North Carolina
Department of Environment and Natural Resources

RE: File No. 0750017917

On June 27, 2007, Krishaun Brewington applied for an improvement permit for Lot B, C.L. Tart Subdivision, Blackman Road, Erwin, NC. James A. Brewington owns this lot which is 0.75 acre. A two-bedroom house is desired. There will be county water. The property corners and house corners are identified in the field. The Harnett County Health Department (HCHD) previously denied the improvement permit.

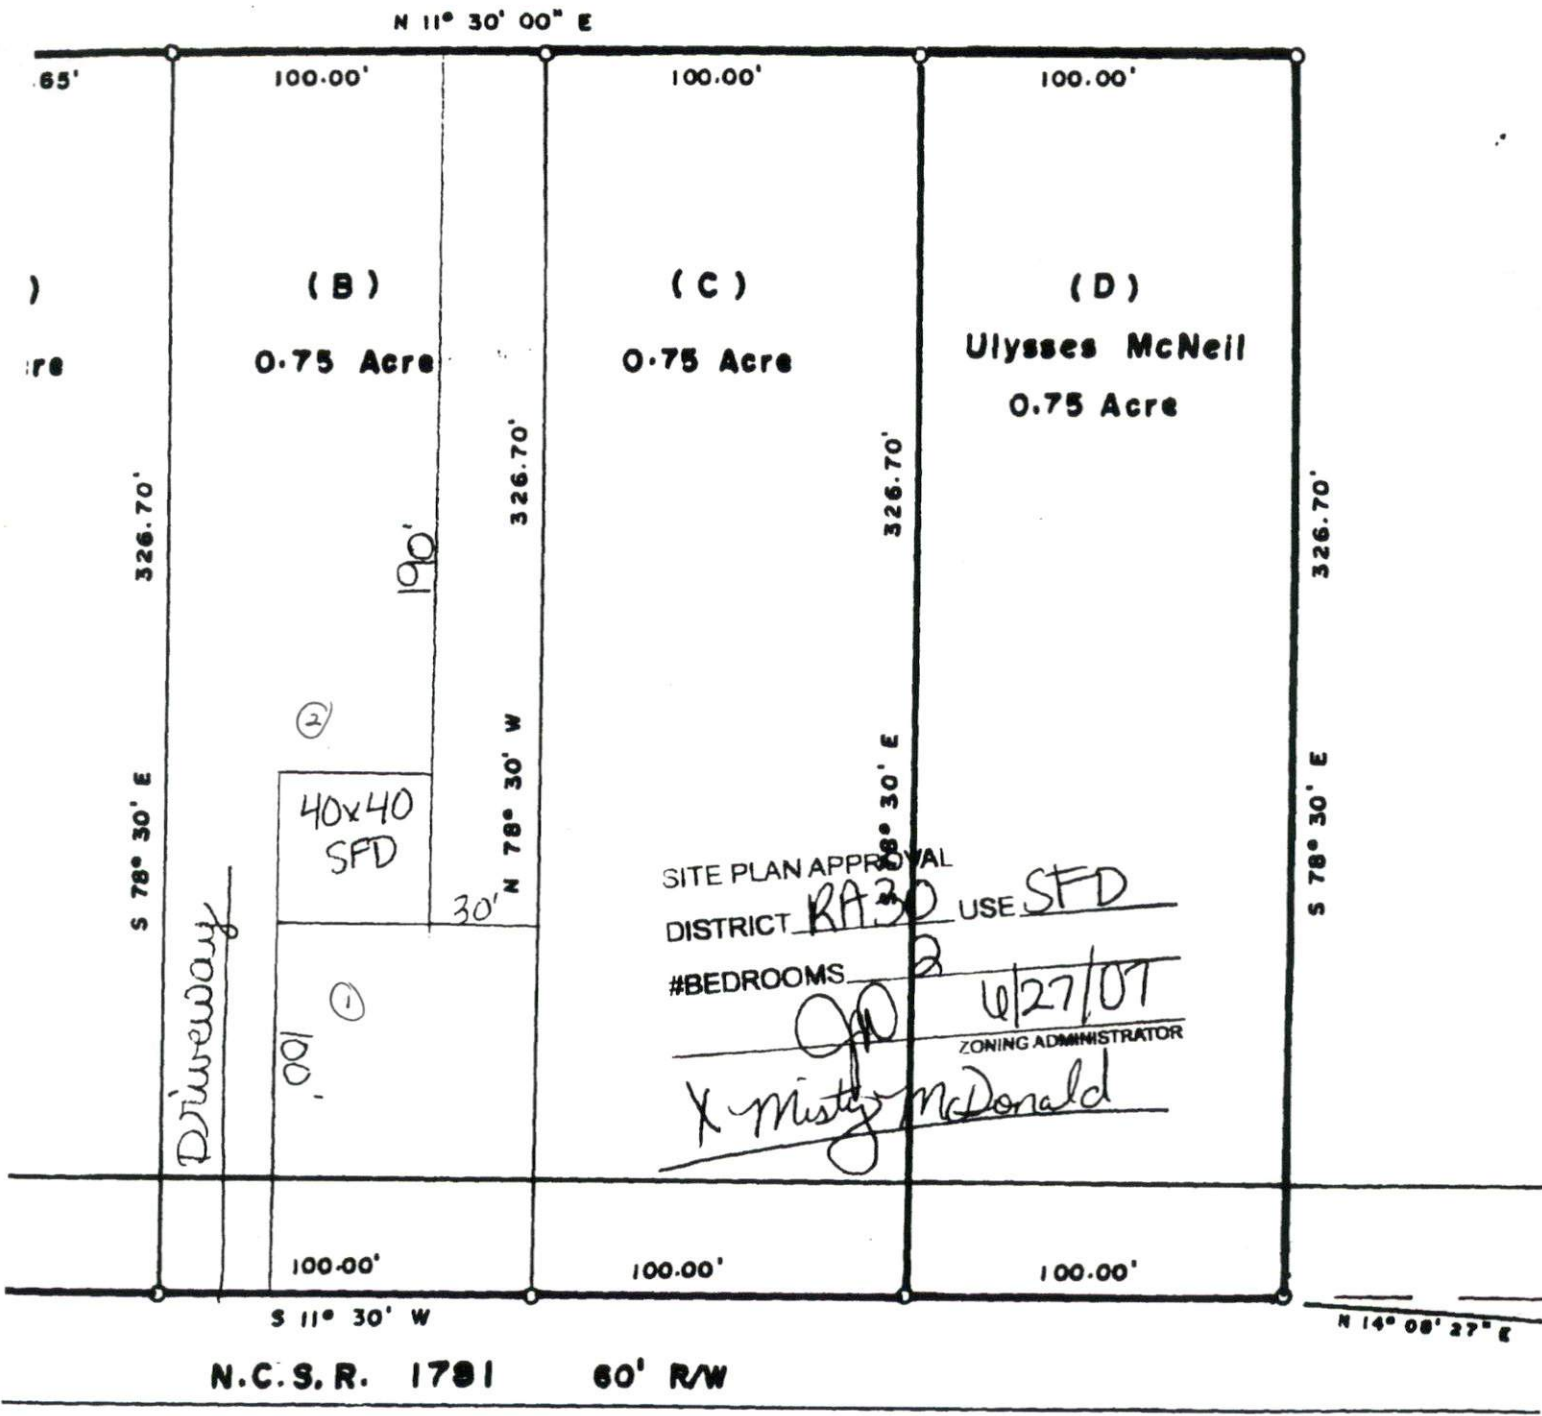
6. Available space (Rule .1945) – **Unsuitable**

- * There is no available space for both initial and repair septic systems.

In summary, an improvement permit for Lot B on Blackman Road cannot be issued due to the following unsuitable soil properties:

- * **Unsuitable soil structure**
- * **Unsuitable soil wetness**
- * **Unsuitable soil depth**
- * **Insufficient available space**

- * She may purchase other property with suitable or provisionally suitable soils to place the initial and repair septic systems. Pumping the sewage effluent off-site from Lot B would be required.
- * She may obtain an easement to other property with suitable or provisionally suitable soils to place the initial and repair septic systems. Pumping the sewage effluent off-site from Lot B would be required.
